Elizabeth Drive, Cecil Park Subdivision (SSD-8859)
Request for Additional Information

I refer to Amended Environmental Impact Statement and Response to Submissions for the Elizabeth Drive, Cecil Park Subdivision (SSD-8859). Further to our meeting on 19 November 2020, the Department is seeking additional information in response to correspondence received from Jemena, Transport for NSW, Fairfield City Council, Heritage NSW, Environment, Energy and Science Group and Western Sydney Parklands Trust, as well as matters identified by the Department. Any additional requests for further information made by agencies will be forwarded to you in due course.

## GAS PIPELINE EASEMENTS

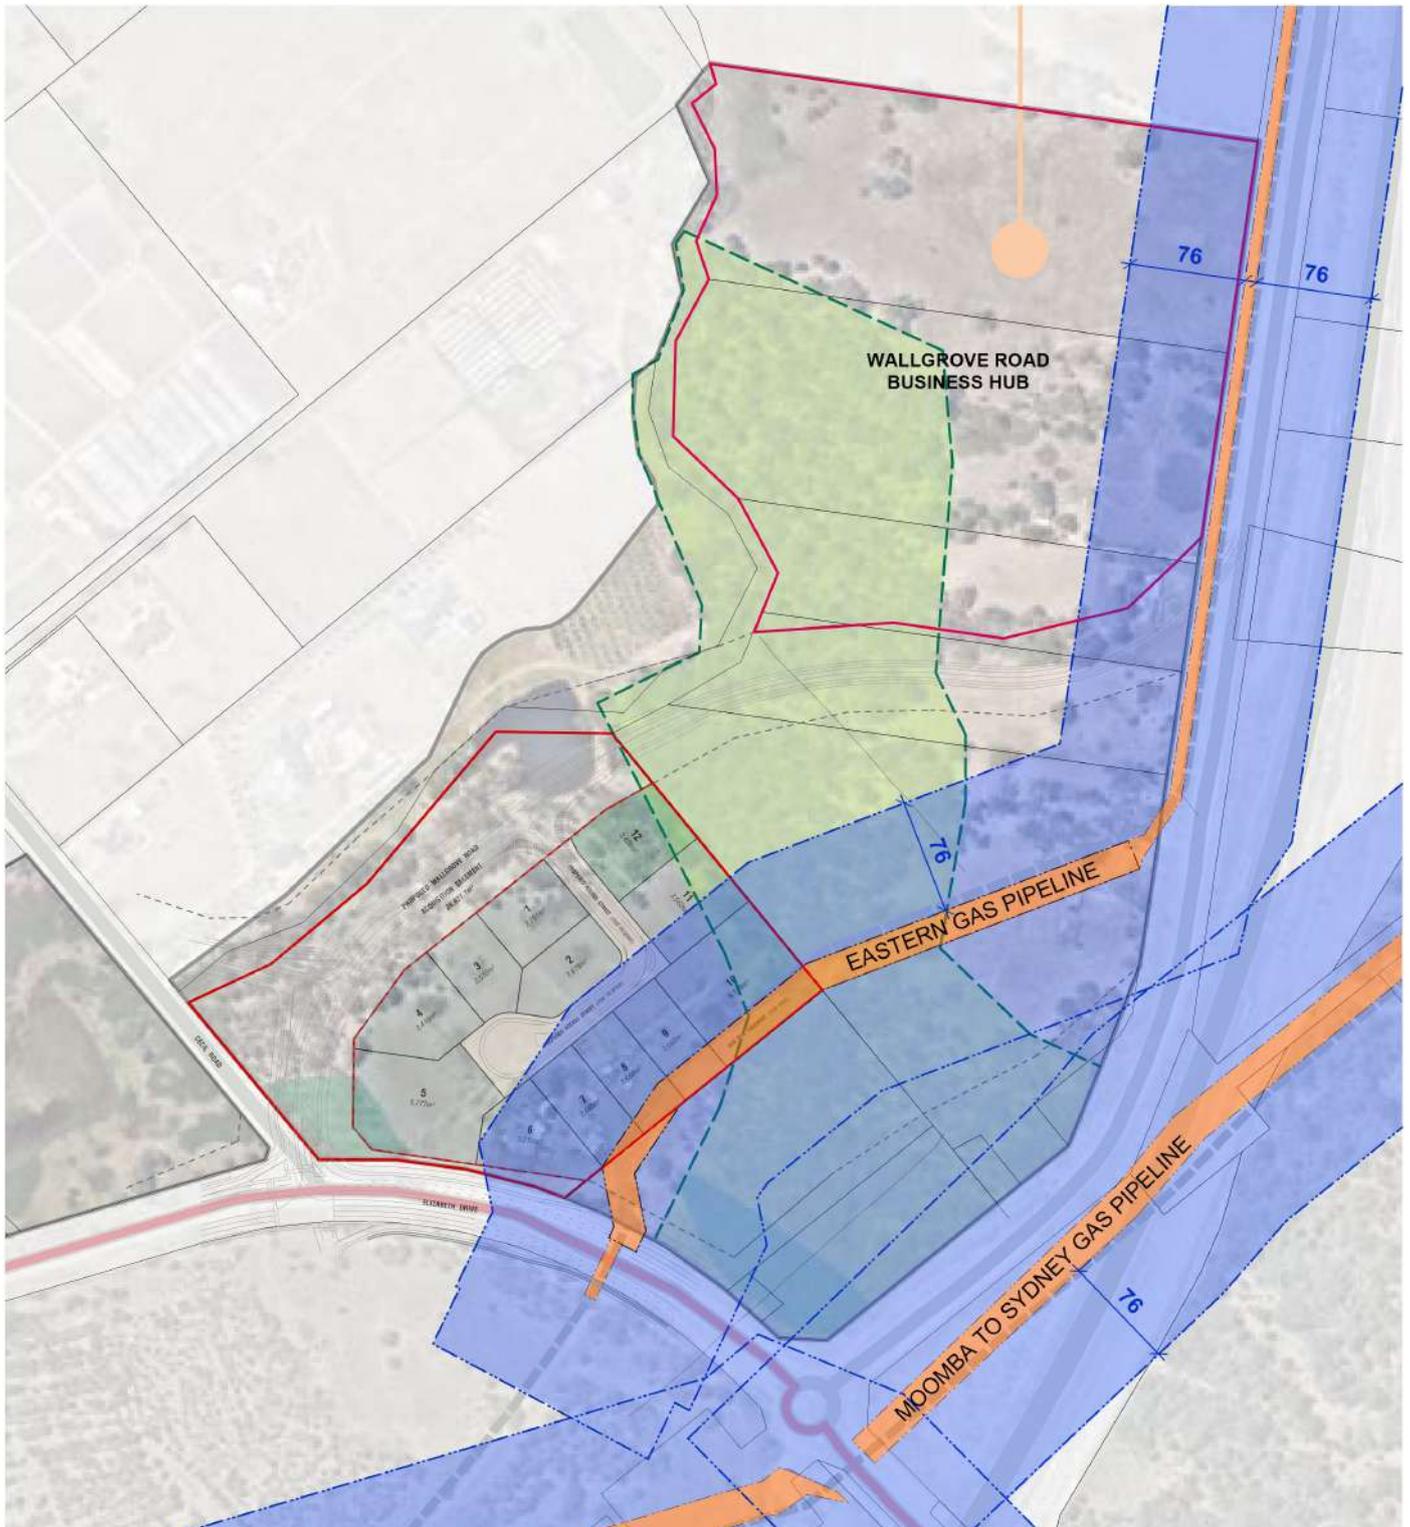
1. The Department considers that further consideration needs to be given to Jemena's submission dated 26 March 2019 and reiterated in its submission of 12 November 2020, particularly relating to future development of the site being located within 76 metres from the boundary of its pipeline easements.

The Department suggests consideration be given to reconfiguring some of the lots so that they don't partially sit within the 76 metre setback. This includes:

- a) realigning lot 5 and lot 6 to ensure lot 5 is wholly outside of the setback
- b) realign lot 11, potentially splitting the lot into two allotments
